**KIRKLEES METROPOLITAN COUNCIL
INVESTMENT & REGENERATION SERVICE**

Reference No: 2018/62/92680/E

Site Address: Poplar Farm, Bristfield Road, Bristfield, Dewsbury,
WF12 0PA

Description: Erection of stable

Sheet Size/Scale 1:250 @ A3
Drawn By AH
Date 30/07/2018
Drawing Status for client only
Drawing No. 1541_16_A

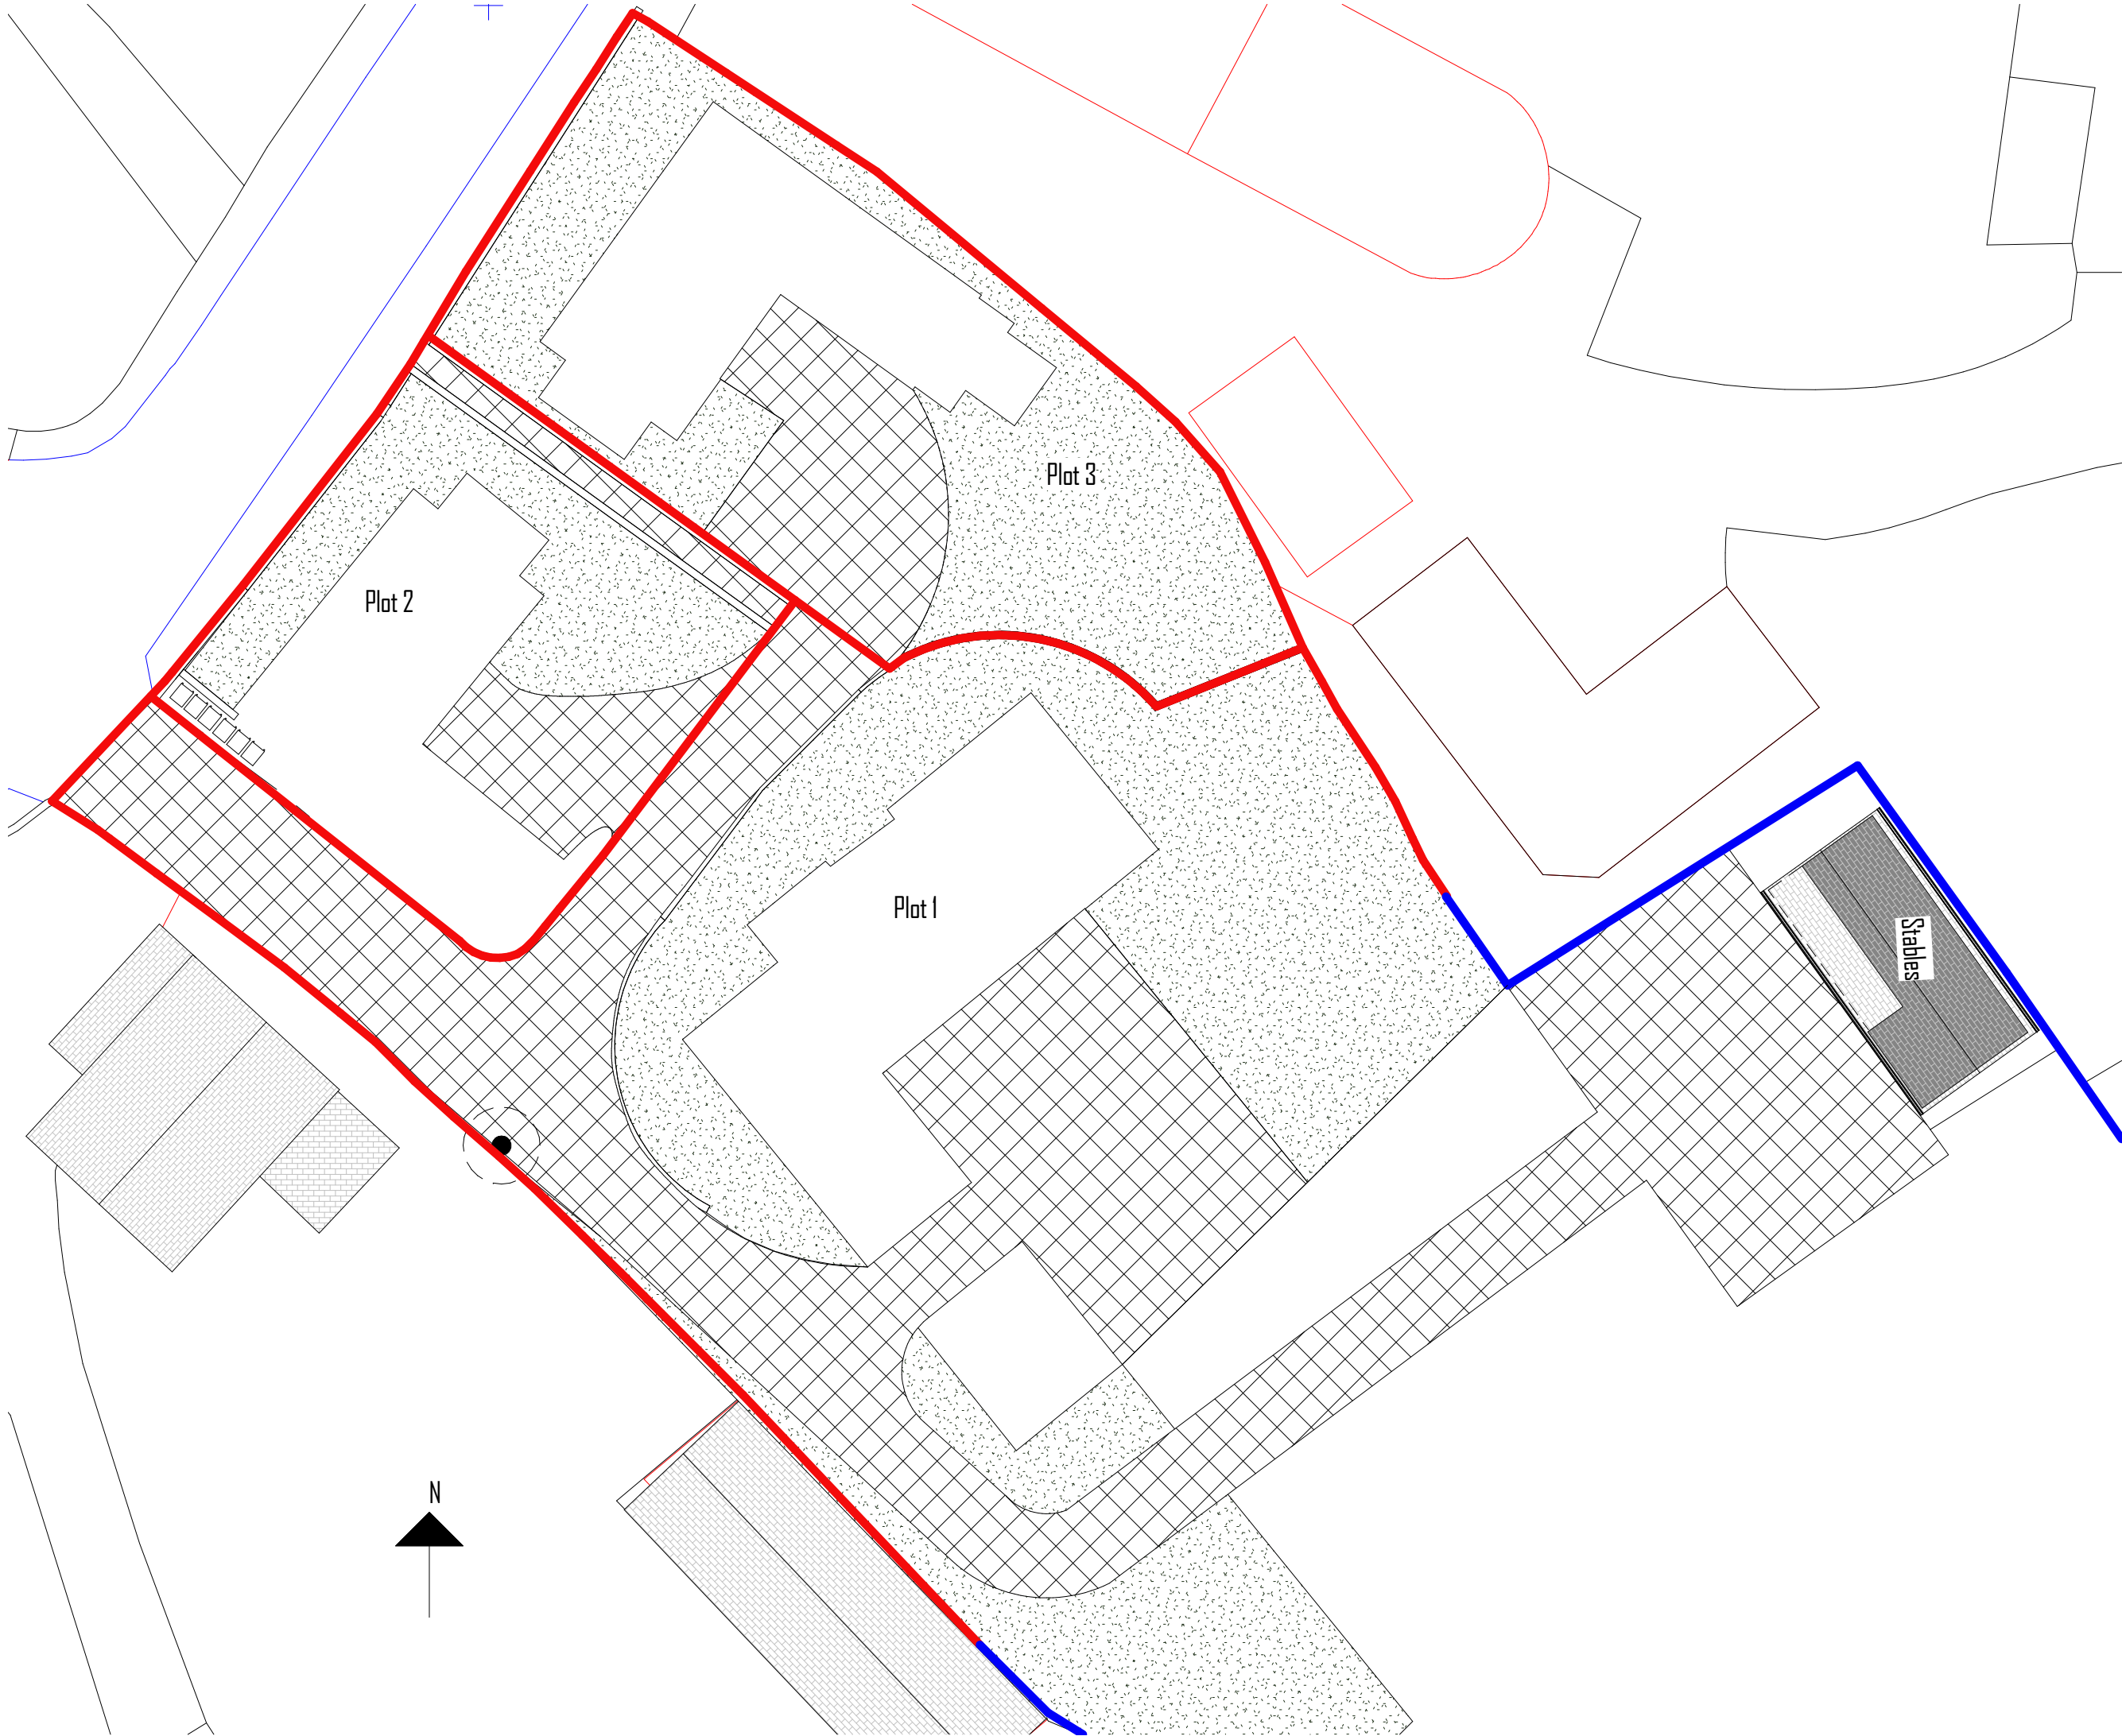
It is also sited at the top of the field away from the more open area of fields to the south; this means that any access to the stable would not result in unnecessary additional development on the site. The original proposal was for an access and yard area which was to be surfaced with block paving/flags, this would have had an adverse impact on the openness of the area by introducing an urban element into the paddock area. The amended plans now propose a narrower access with a smaller yard area; both would be surfaced with crushed stone or similar.

3. The access and yard area as shown on the approved plan ref: 1541_16_A, received 8/11/18 shall be surfaced with crushed stone before the stable block hereby approved is first brought into use and thereafter retained.

Drawing No. 1541_17_A

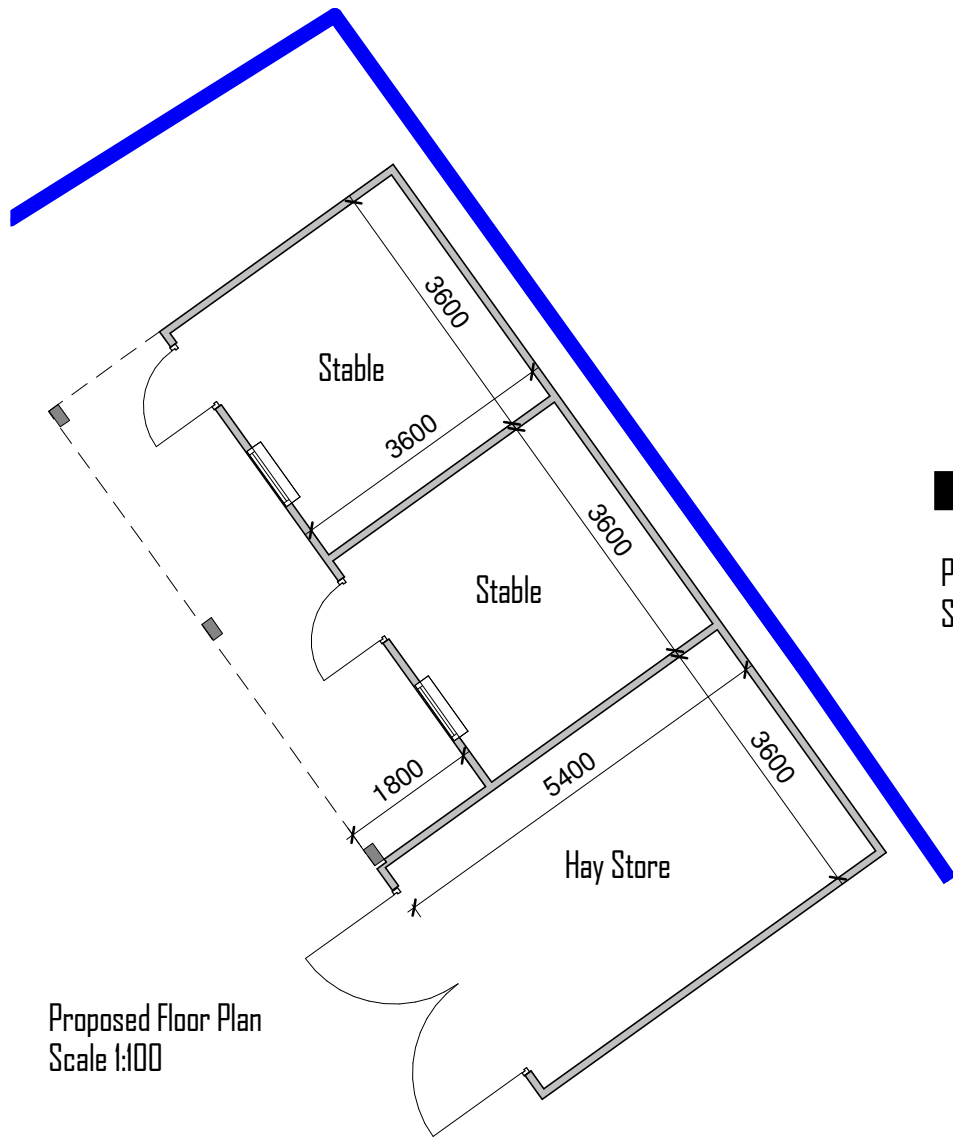
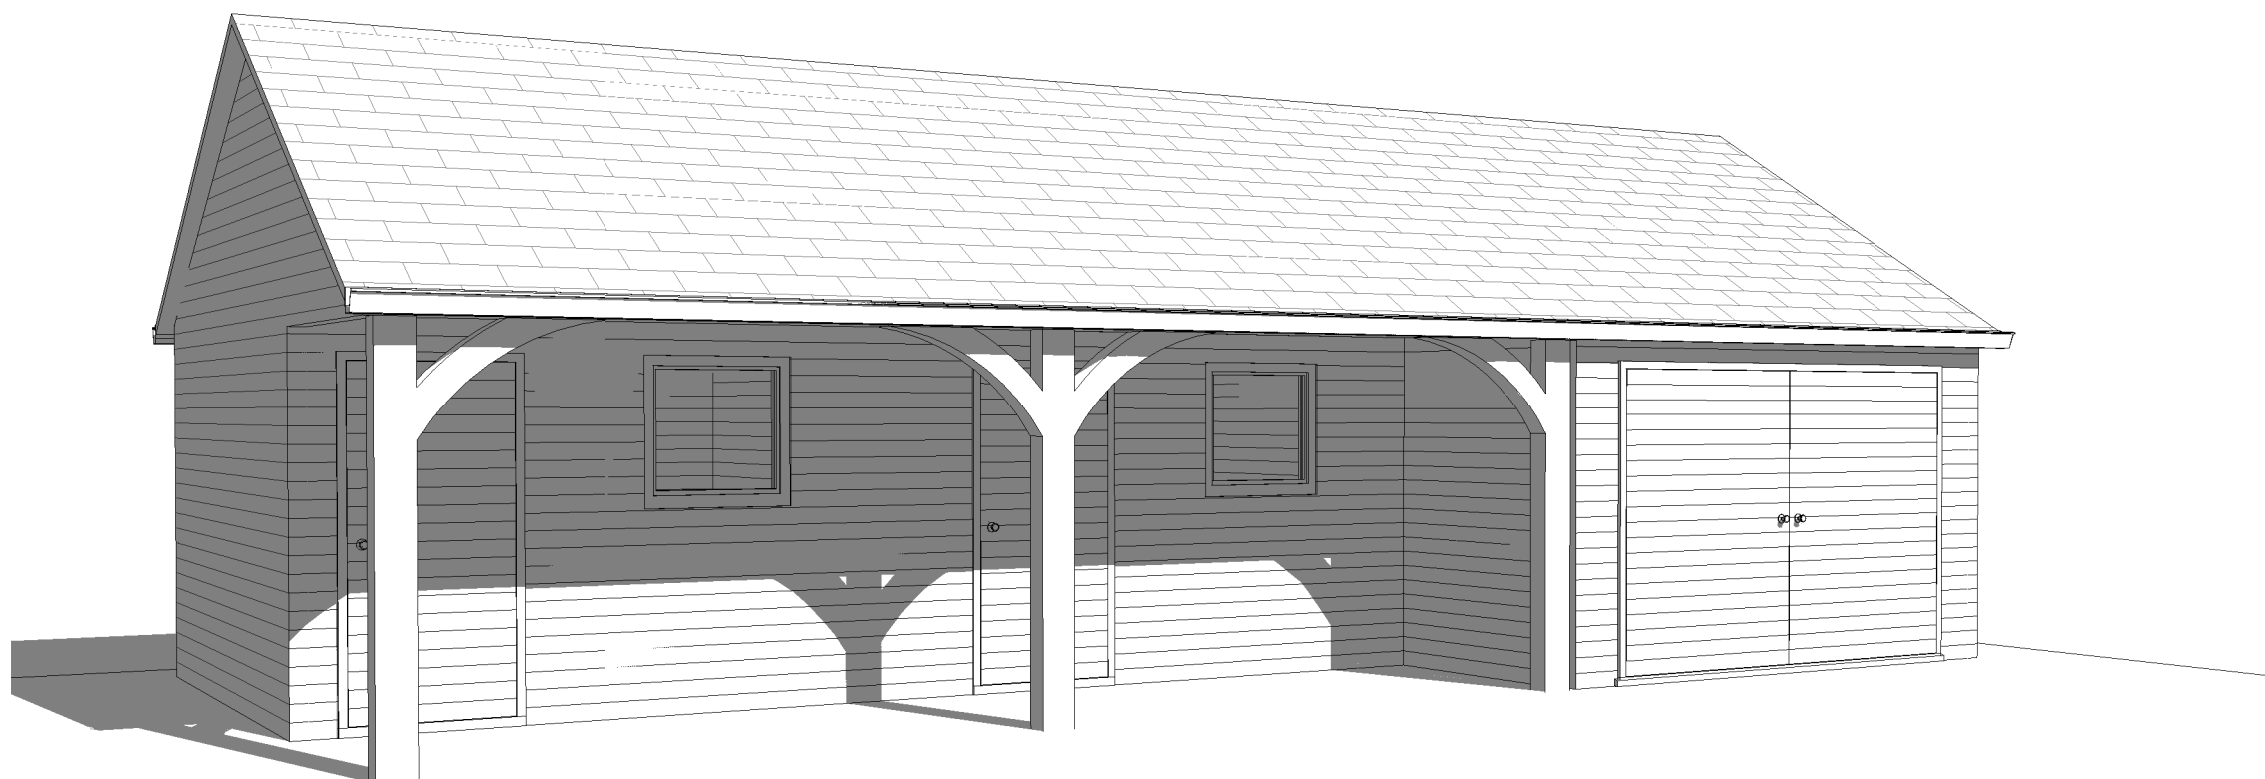
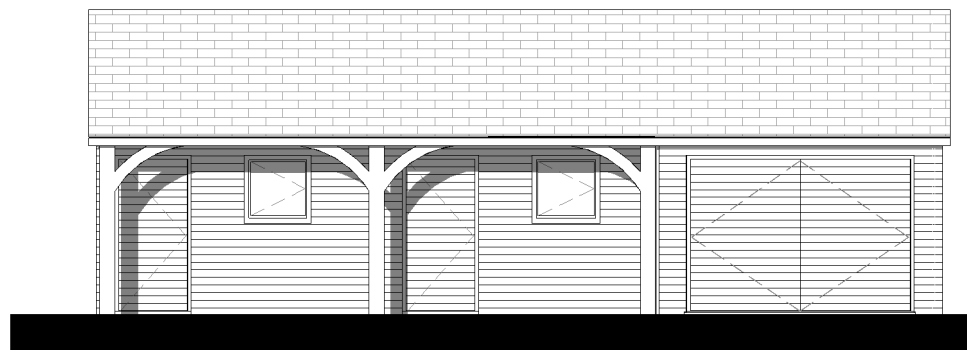
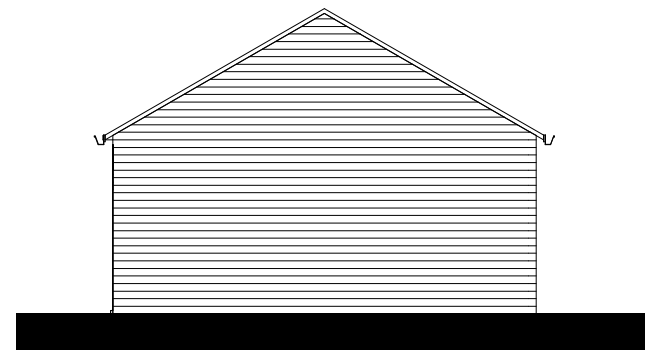
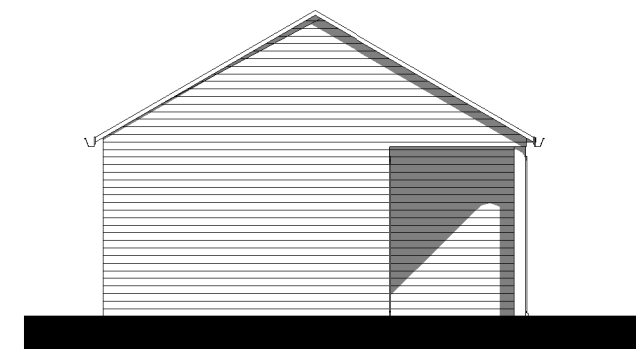
The proposal is for the erection of a stable block to the rear of plot 1 on the site. The stable would have two stable boxes and a feed store and would be built in an "L" shape, measuring 10.8m wide x 5.4m from front to rear and the deepest point.

Materials would be horizontal timber cladding with Onduline roofing. The track and yard to the front of the building would be surfaced in crushed stone or similar.

In addition, the stable would have reasonably low eaves and ridge height, being the minimum necessary for a stable block and would be constructed from appropriate materials being corrugated fibre cement “Onduline” roofing and horizontal timber boarding.
